18th December 2015

The Secretary
NSW Department of Planning and Environment
GPO Box 39
Sydney NSW 2001

State Significant Development Application and Variation of the Sydney Cove Redevelopment Scheme for the “*Remediation, Renewal and Adaptive Re-Use of Campbell's Stores*”, The Rocks (SSD 7056)

03 NORTH ELEVATION  
SCALE 1:200

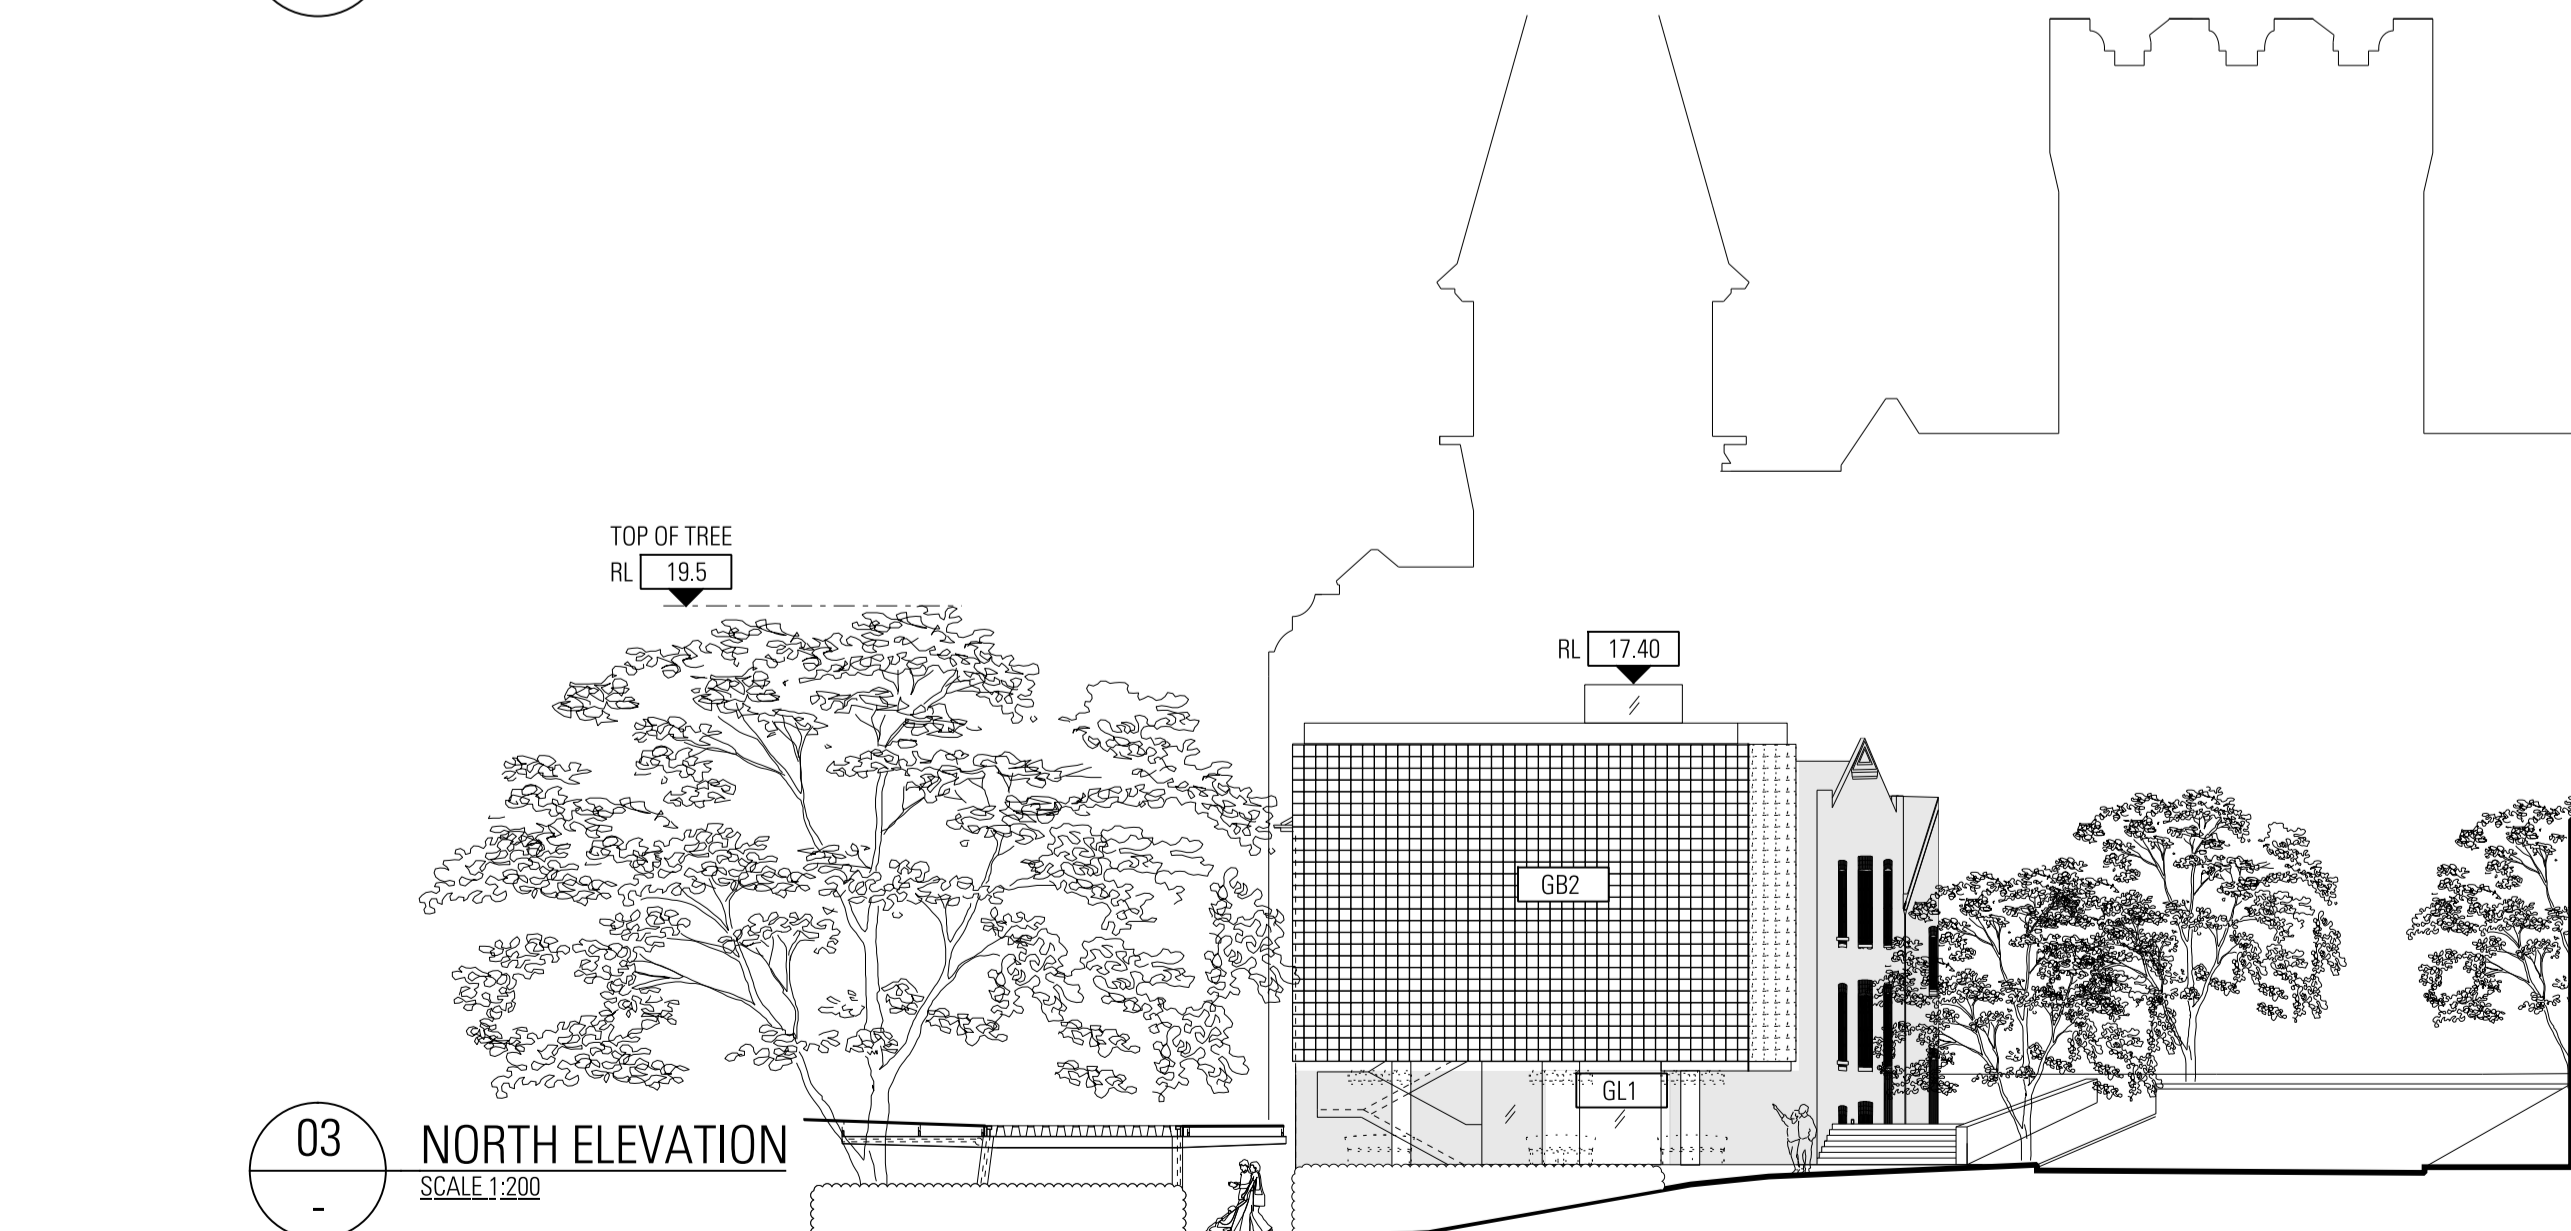
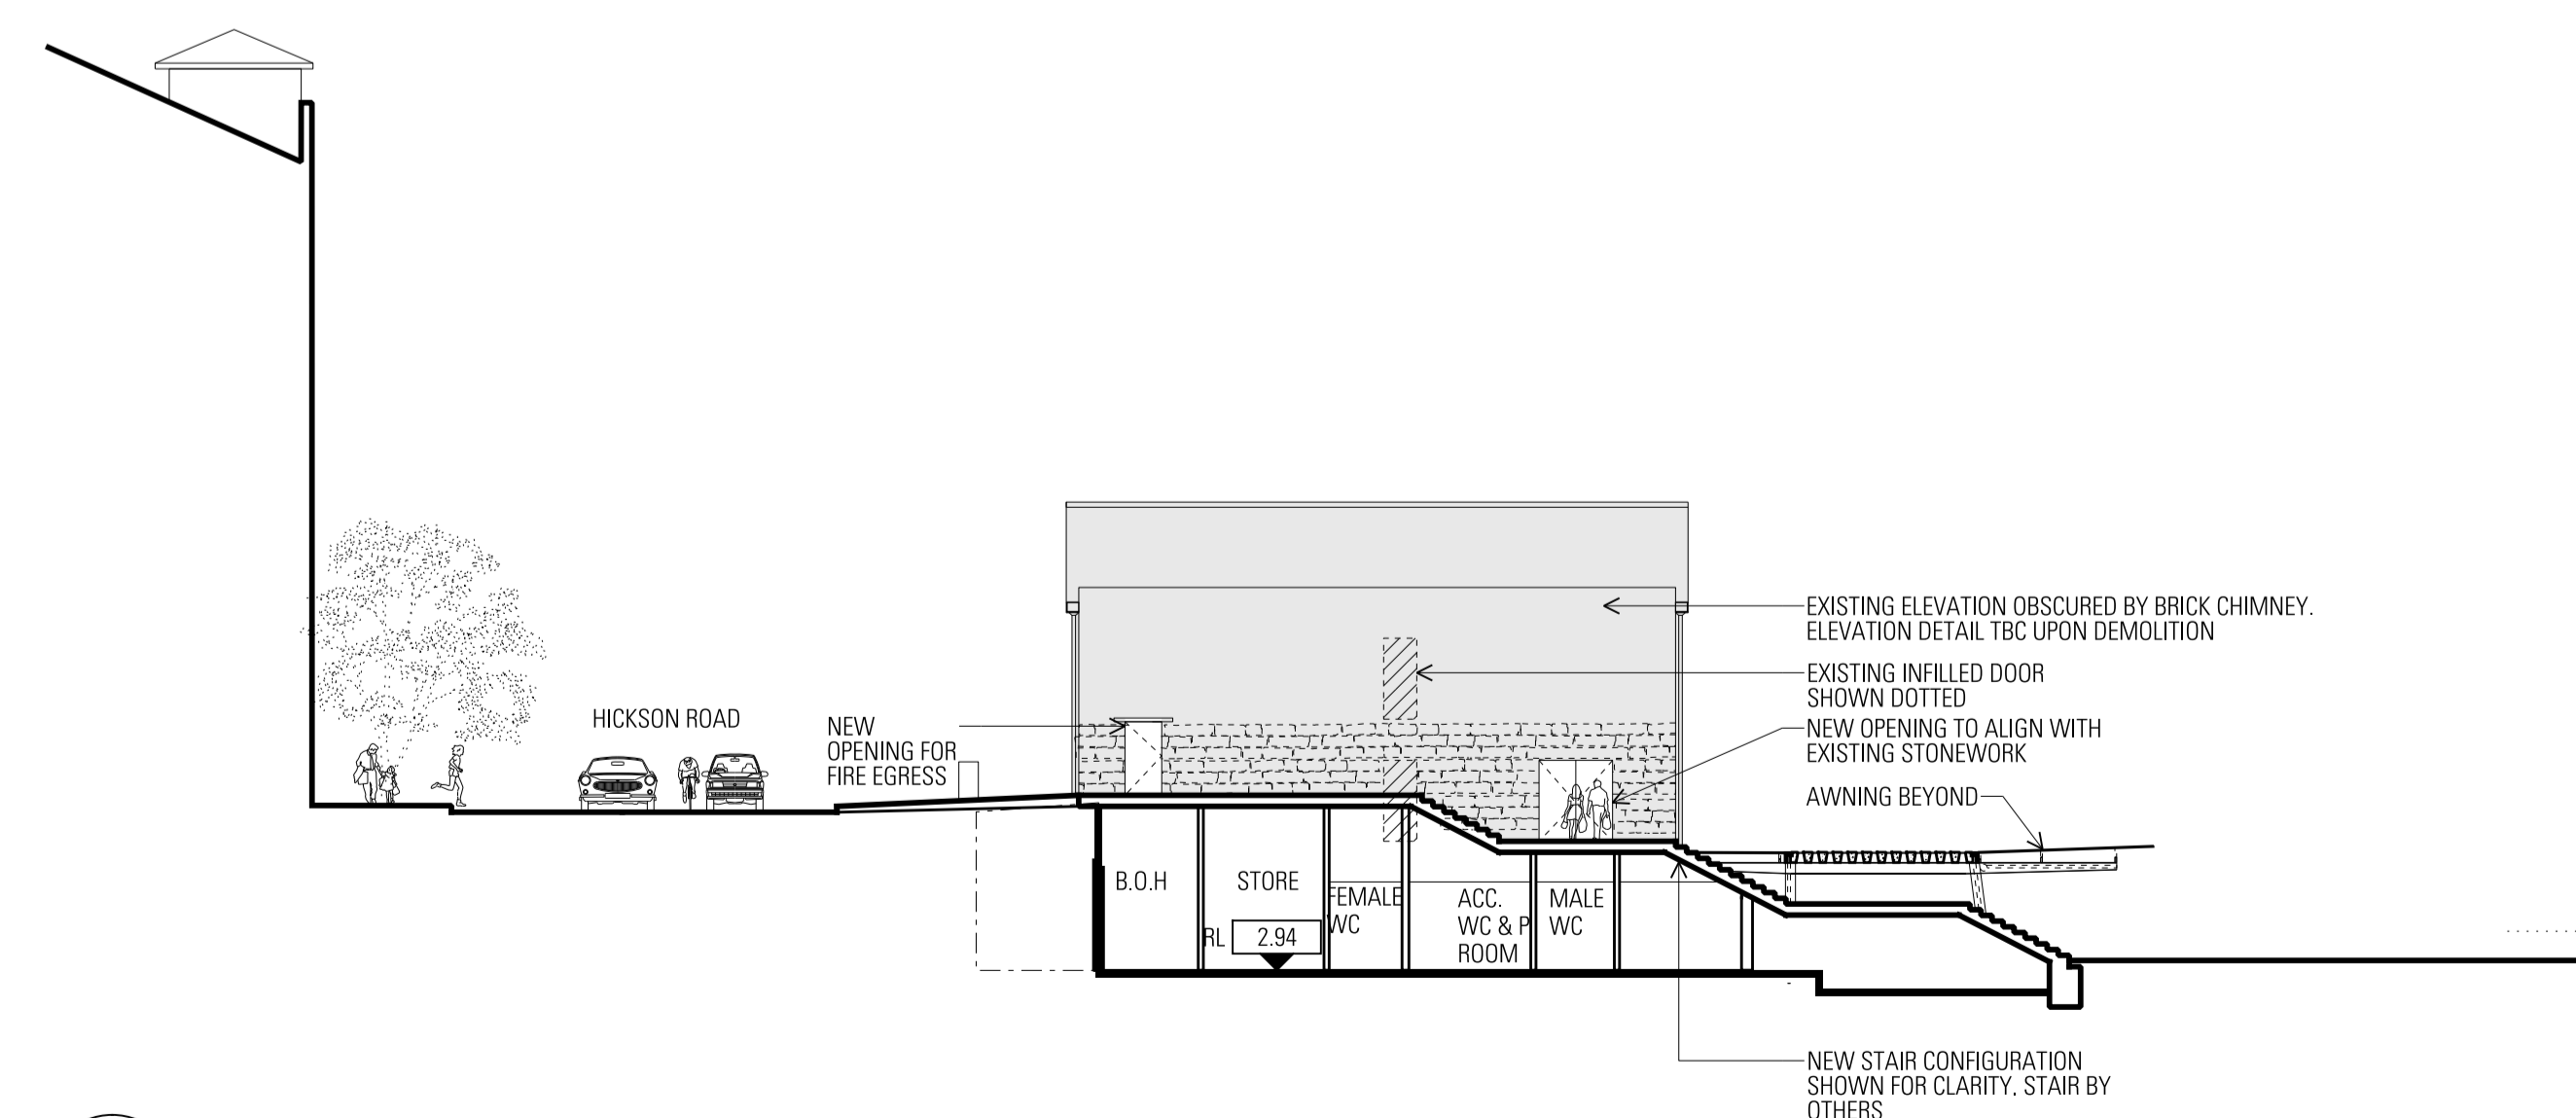
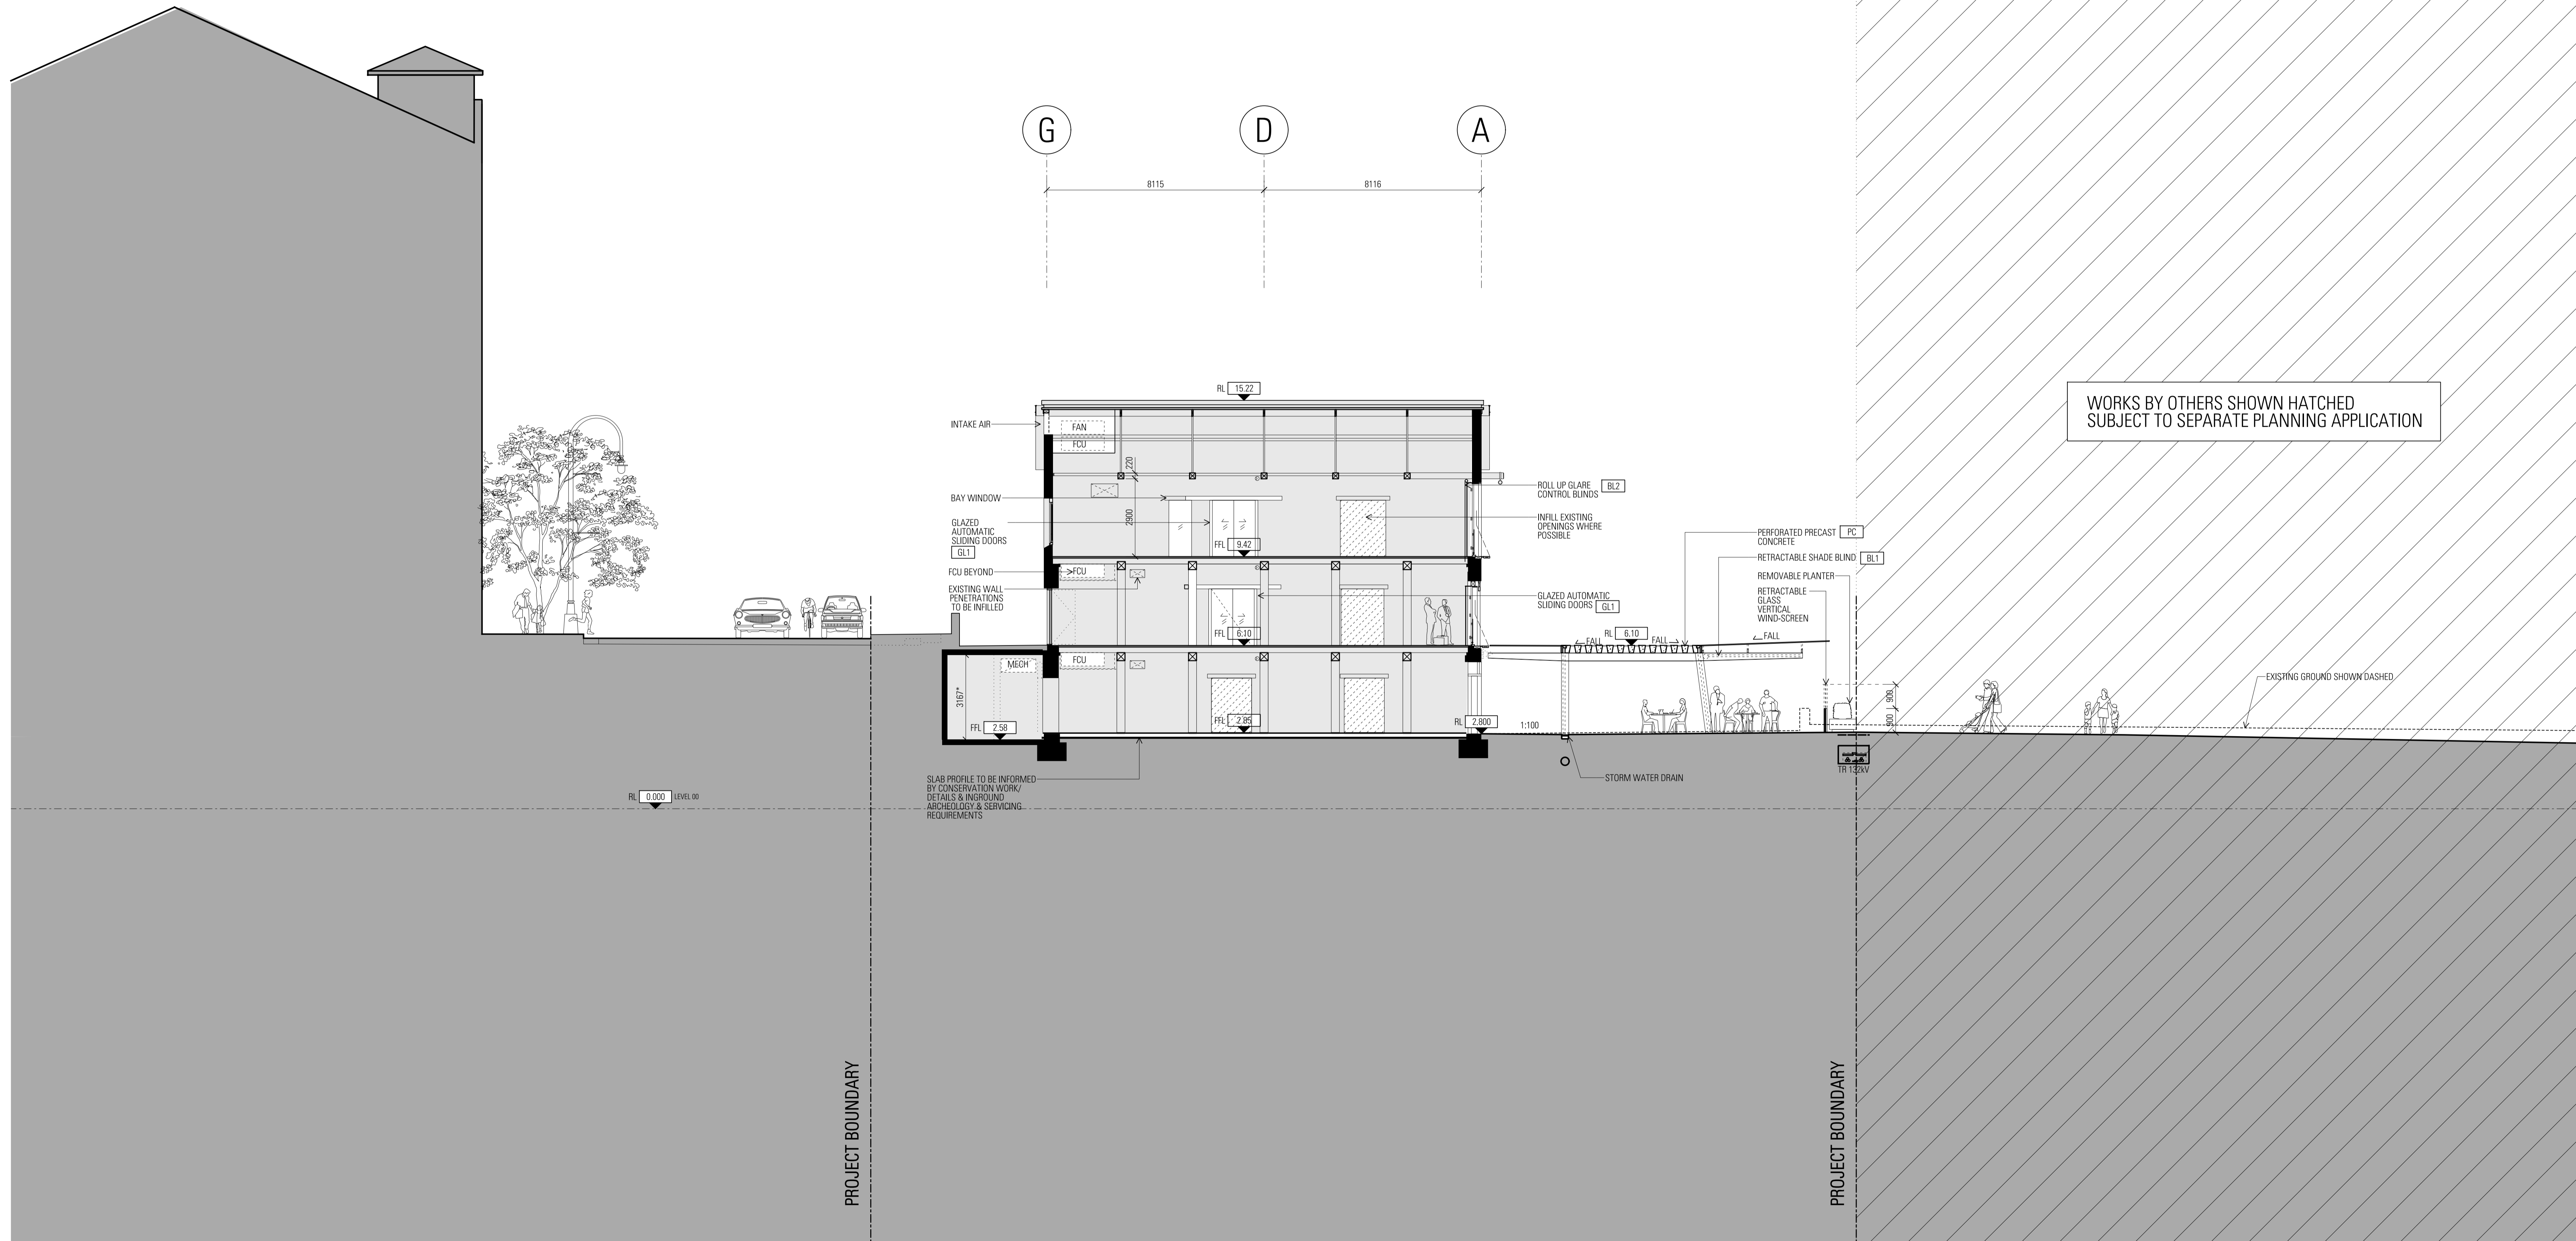
- The glass building would comprise three levels sitting on four columns. It would have the appearance of a tall and bulky glass box on stilts and would obscure all of the Stores' northern elevation. Its minimal 2.5 metre undercroft would be oppressive and tunnel-like and this, along with its intended use for outdoor eating, would serve as a barrier, limiting public access to the foreshore and severely constraining existing views to the Opera House from this location.

- The proposed glass box would be located next to Bay 11 on the northern elevation of Campbell's Stores. When measured from the proposed new ground level, it would be 13.3 metres high with the inclusion of its 1 metre high lift overrun. This exceeds the height restriction on the foreshore frontage by 14.5m, more than 250% and on the Hickson Road elevation by 10.5m, or 140%. **This would require a significant spot re-zoning under the Sydney Cove Re-Development Authority Scheme (SCRAS). One-off variations to this should not be permitted in advance of the Premier's holistic review of planning for the Sydney harbour foreshore.**

- The proposed new ground level would be 1.94 metres higher than the existing one so as to accommodate a basement area. Contrary to claims that there would be a four metre setback between the two buildings, the basement level of the glass box would abut the Stores and effectively bury the ground floor of the Stores' 'Highly Significant' northern façade almost to the tops of its existing windows. This is shown very clearly in the following sections of JPW's Design Statement – the northern elevation profile (p.96,) the Concepts diagram (p.102) and the Bay 12 'artistic impression' (artistic

- The glass box would destroy the opportunity for people to appreciate Campbell's Stores' significance as a stand-alone industrial building within its maritime setting. It would obscure views of the northern elevation of Bay 11. This would be particularly the case for people trying to view the Stores from the northern end of Hickson Road, from the pedestrian pathway on the eastern side of the Sydney Harbour Bridge and from Dawes Point Park. (see Appendix C2 Photomontages 6a and 7a). Its raised ground level would 'bury' most of the ground floor of the Campbell's Stores northern elevation.
